Planning reference: FG/42/19/HH
22 Singleton Crescent, Ferring BN12 5DG

Single storey front extension, side extension, conversion of garage to habitable use and conversion of roof space to habitable use to include a rear dormer and 3 front roof lights.

Comments on subsequent correspondence between Atterbury Moore Associates and Planning Department at Arun District Council

PROPOSED GROUND FLOOR PLAN 1:50

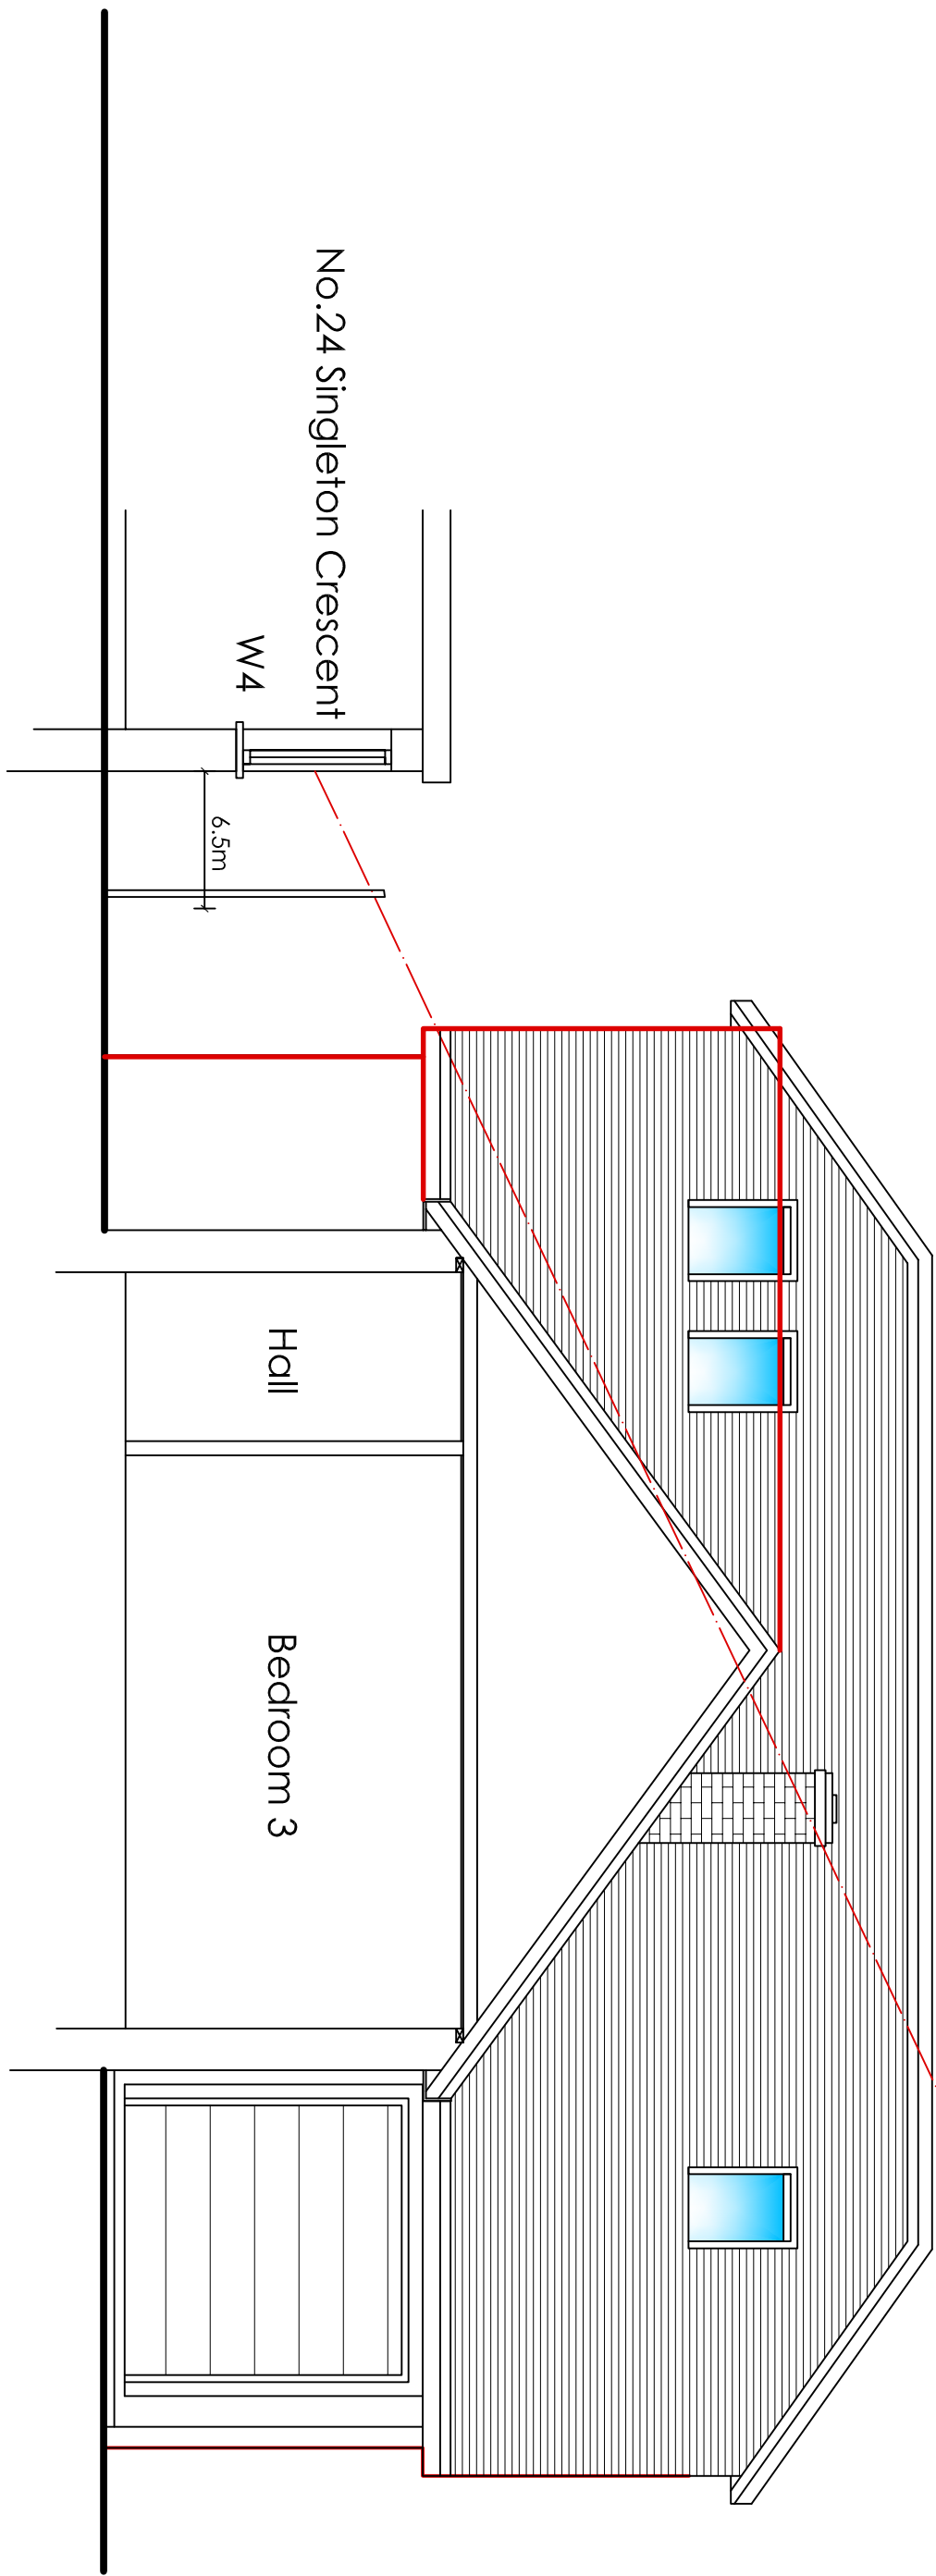
2. Regarding the request by yourselves for a 45 & 25 degree angle light test from a lay persons point of view it would appear that Mr Moore has failed to provided the information you required in that he has given dimensions and angles from W2 rather than W3 or 4 as per your request.

AR-138-09

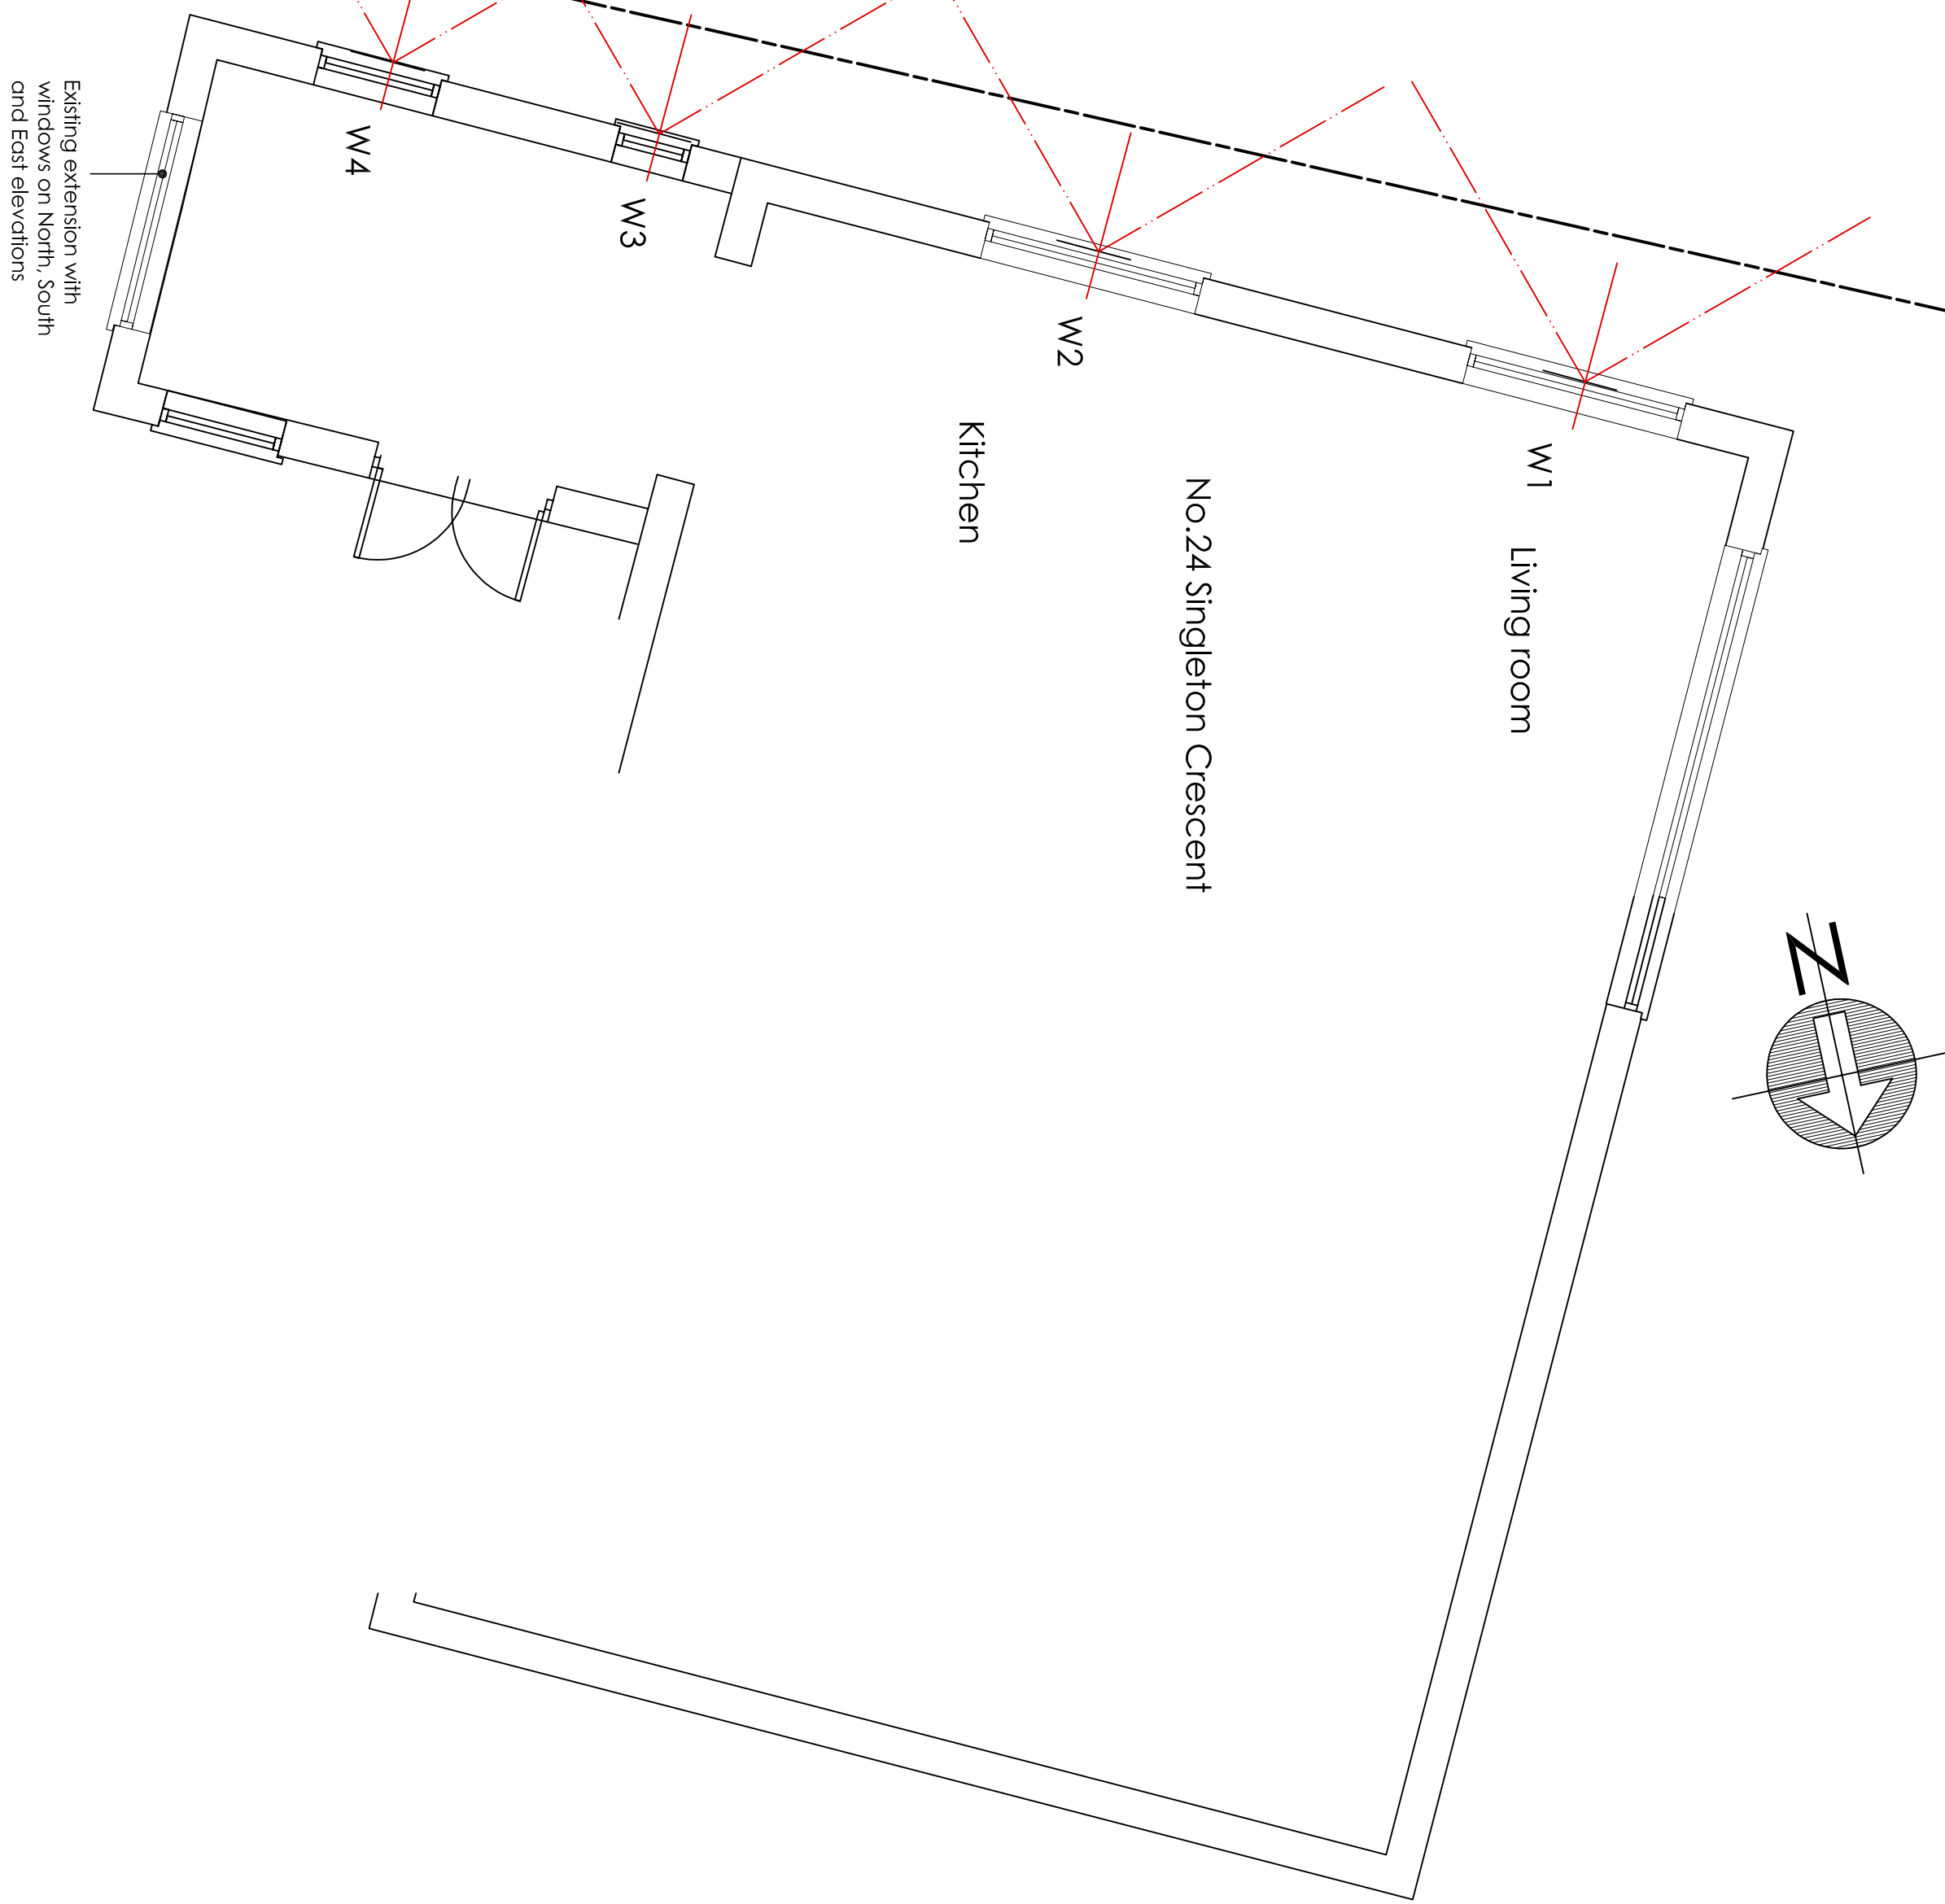
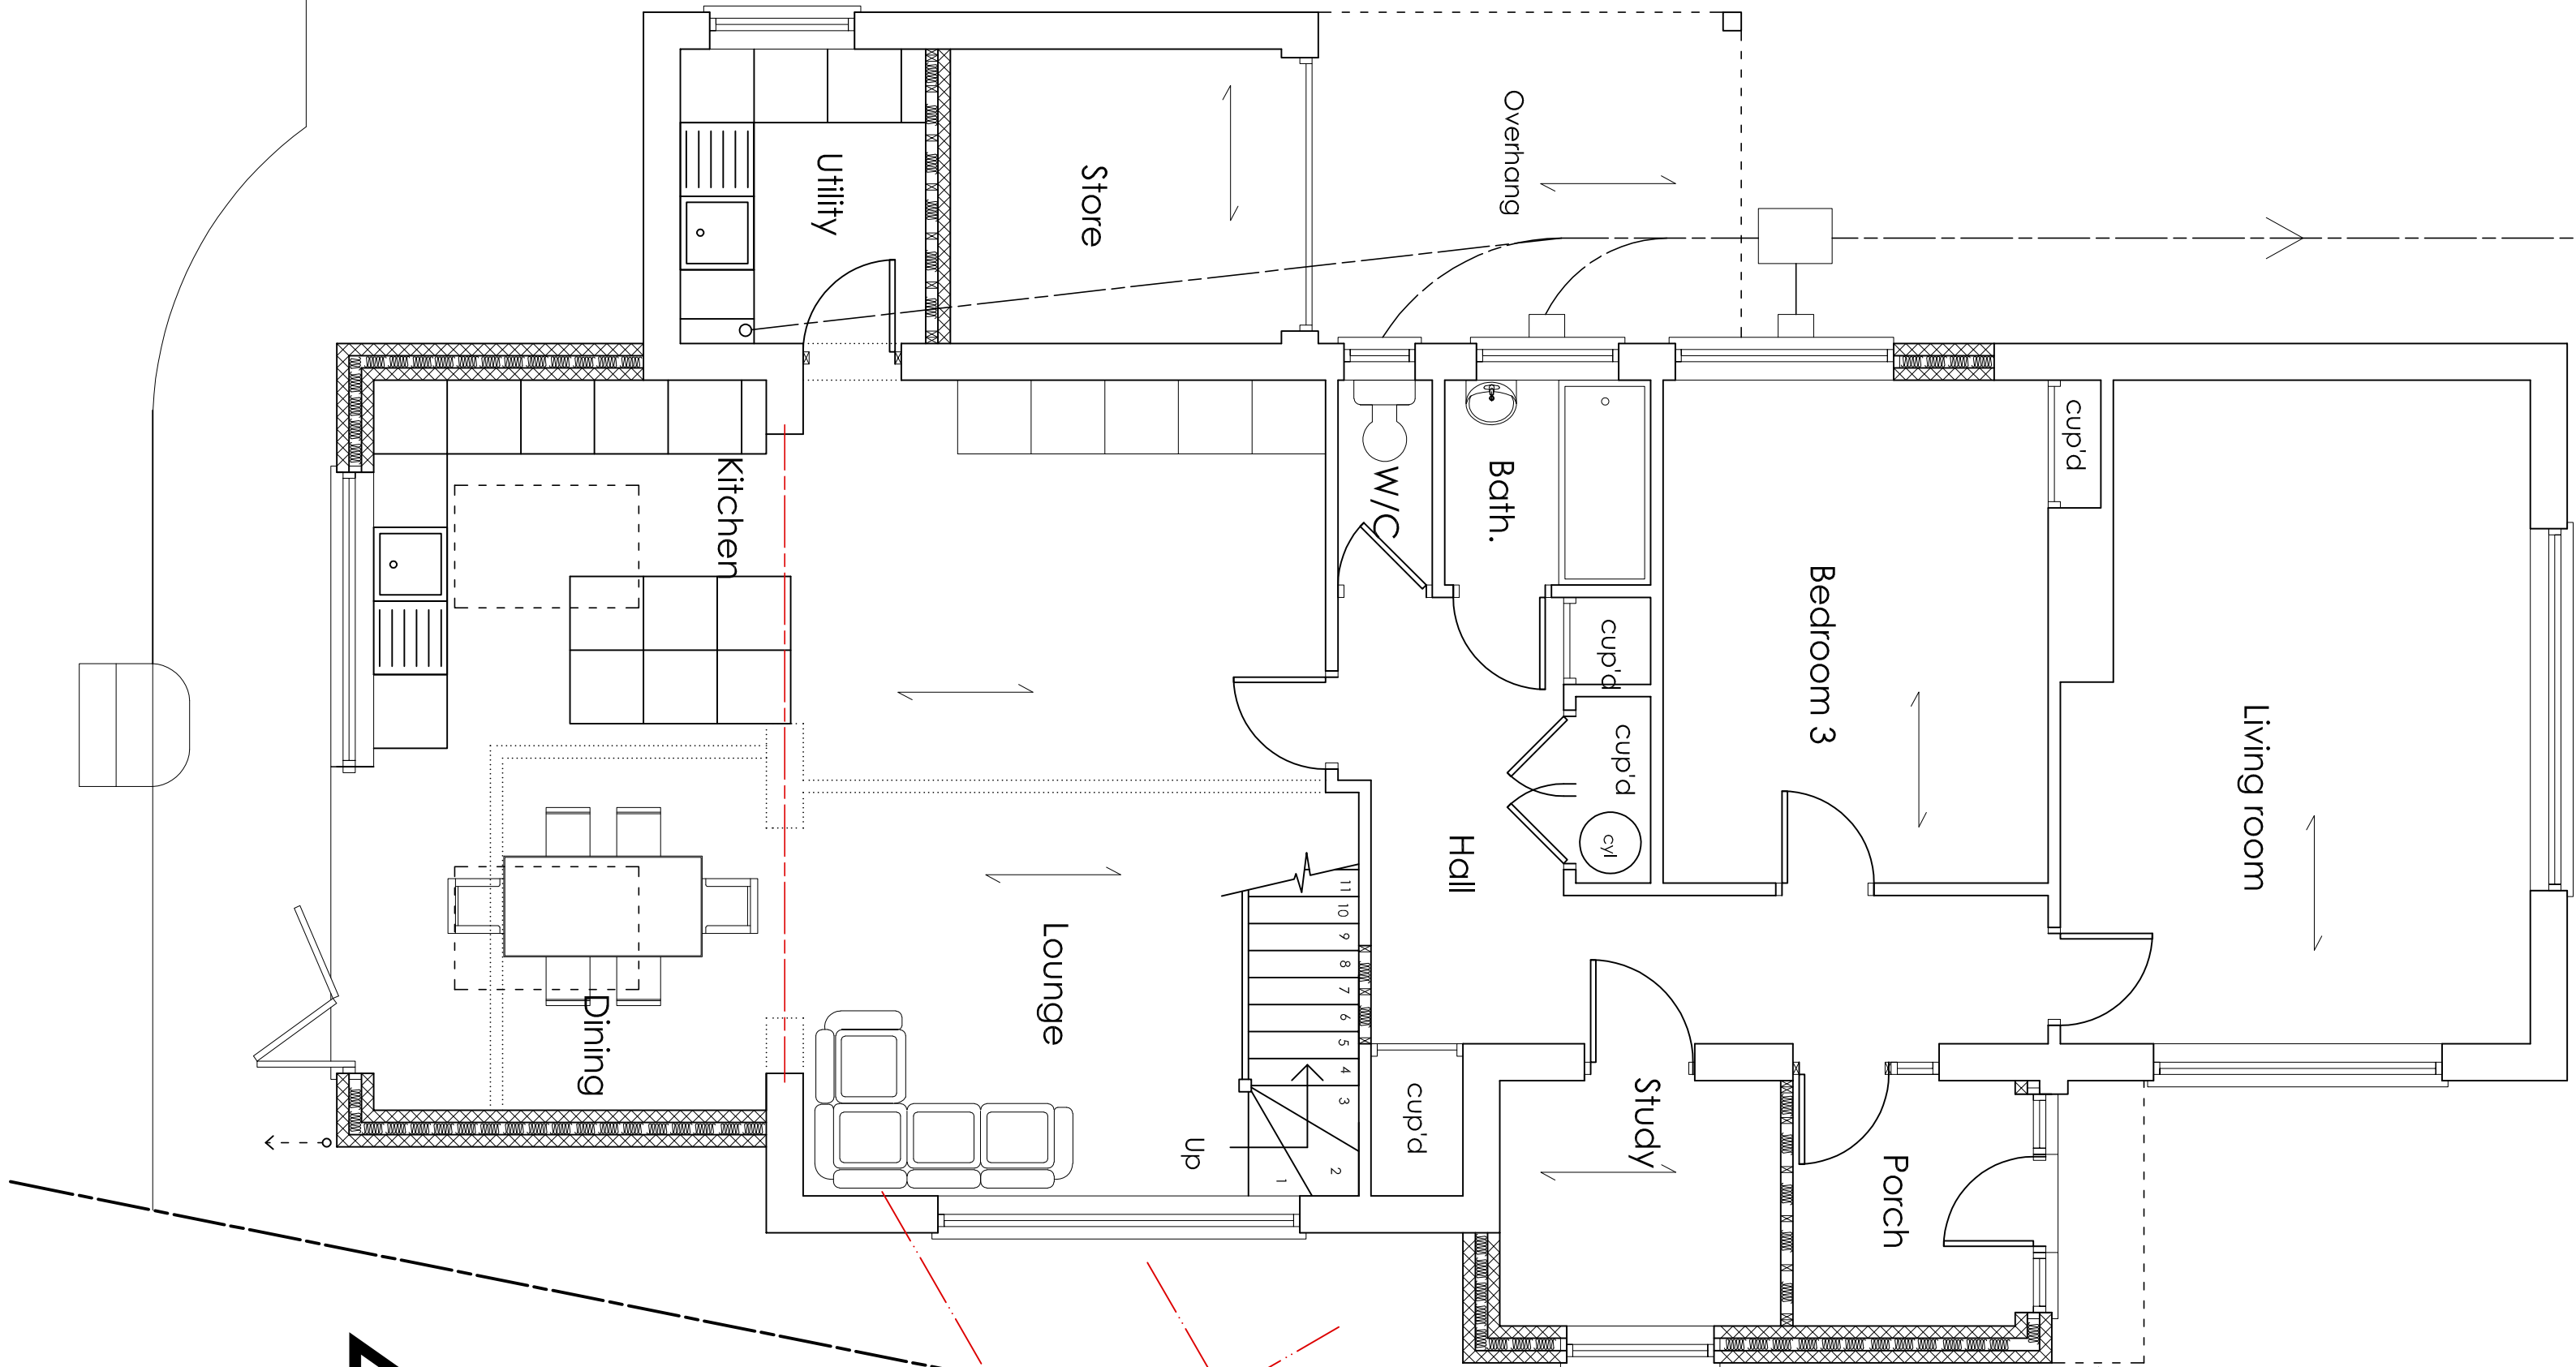
3. The comments by Mr Moore regarding the west elevation window of our property is irrelevant, just because we have a window on the front of our bungalow does not alter the fact that the side will be overshadowed.
4. The W2 window serves our dining room not our kitchen or lounge and the rooms have doors not as shown on Mr Moore's plans. This room is very reliant for light from window W2.
